The Director
Metropolitan and Regional Projects North
GPO Box 39
SYDNEY NSW 2001
Re: Application SSD 5314
Location: Pymble Ladies College
20 Avon Rd Pymble
(Lot1 DP 6941 & Lots 1-26 DP 7131)

I wish to make a submission regarding the development application:
Pymble Ladies College, Staged Development Proposal, Application SD 5314

PROJECT PLC Aquatic Centre		PROJECT # 2126
CLIENT Pymble Ladies College		DWG # A102
DWG Parking numbers- Proposed		REVISION A
CLIENT REF & CONTACT Avon Rd, Pymble NSW 2071	DATE 20/08/12	DRAWN CHKD

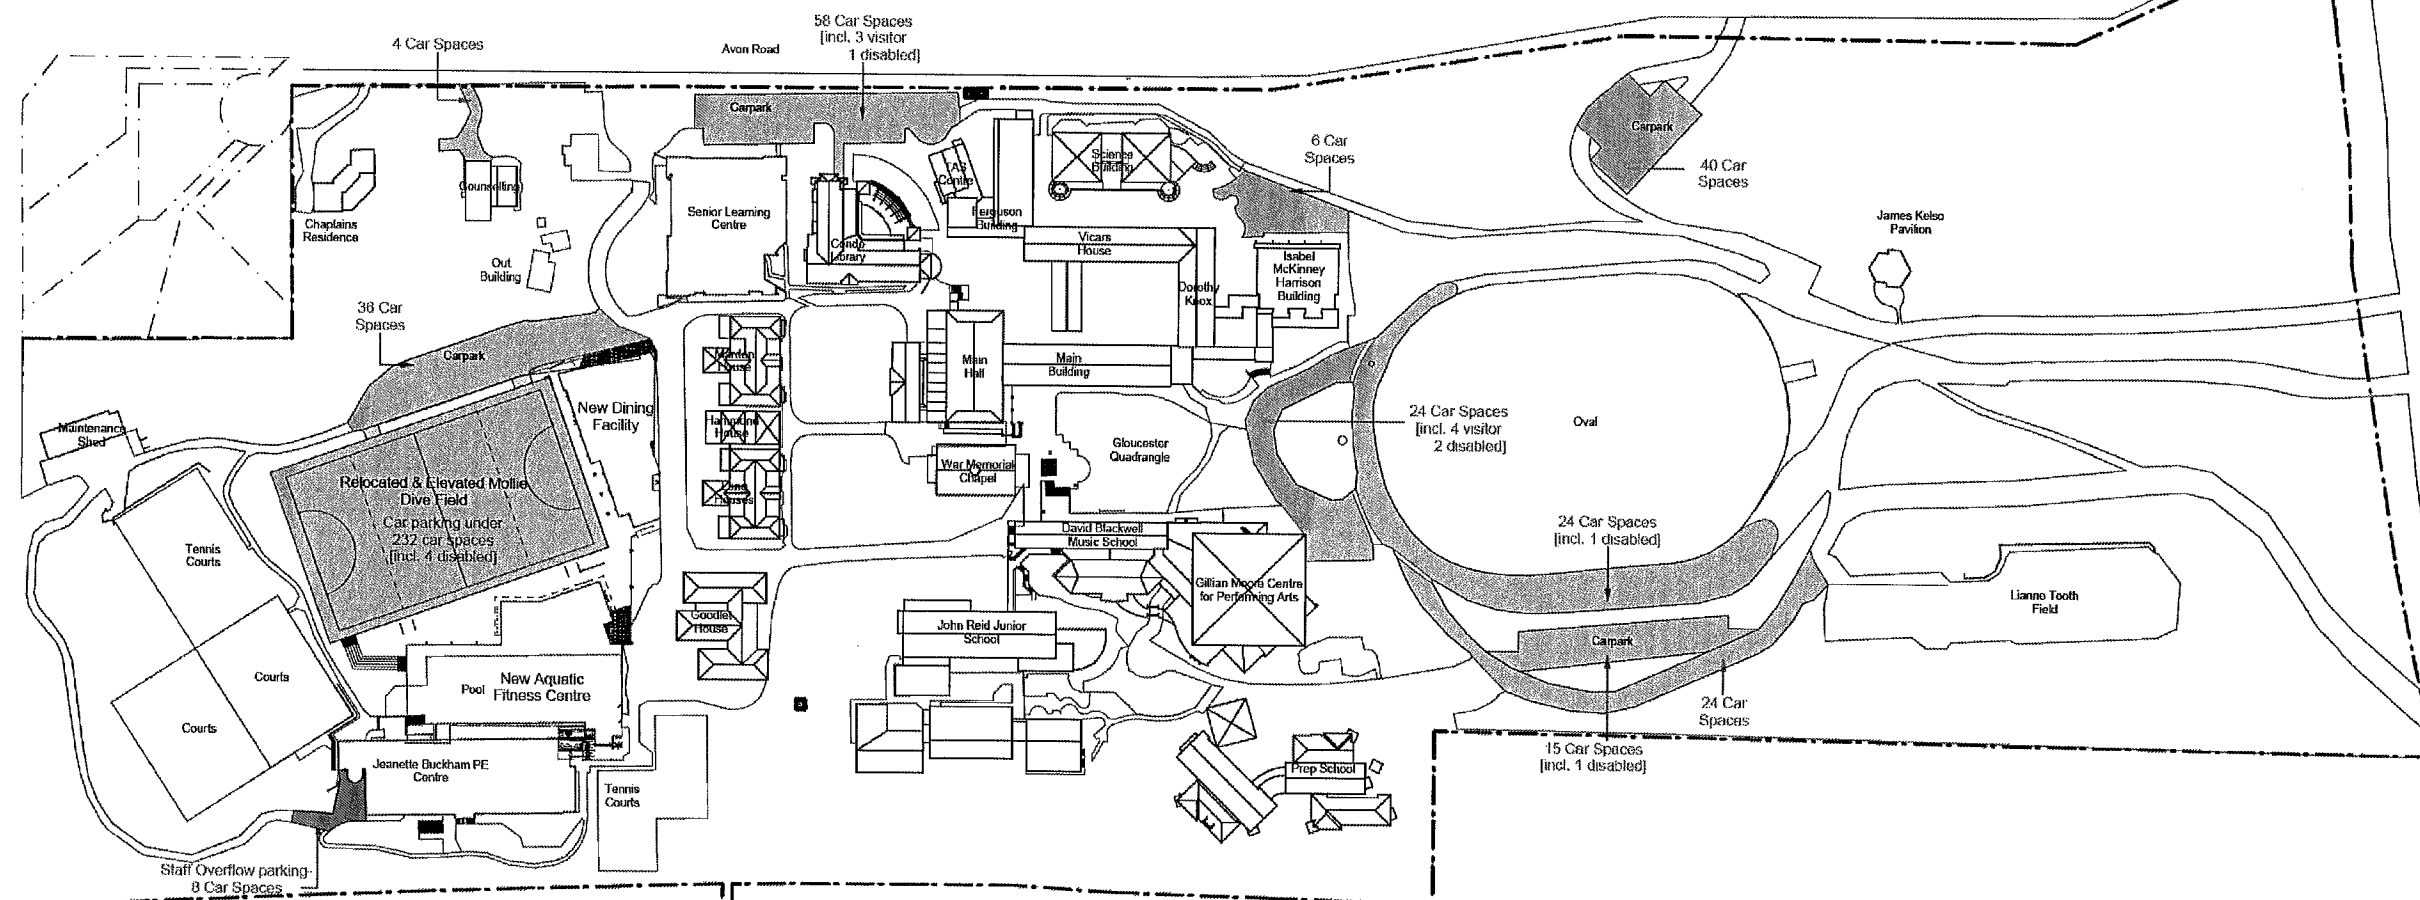
While the new 232 space car-park is not a total addition of 232 car-park space on the site, (because the College will lose 15 existing spaces along access roads to the site and another 21 car-spaces from the current car-park), the addition of parking is welcome, provided the issues of entry and exit from the site is improved.
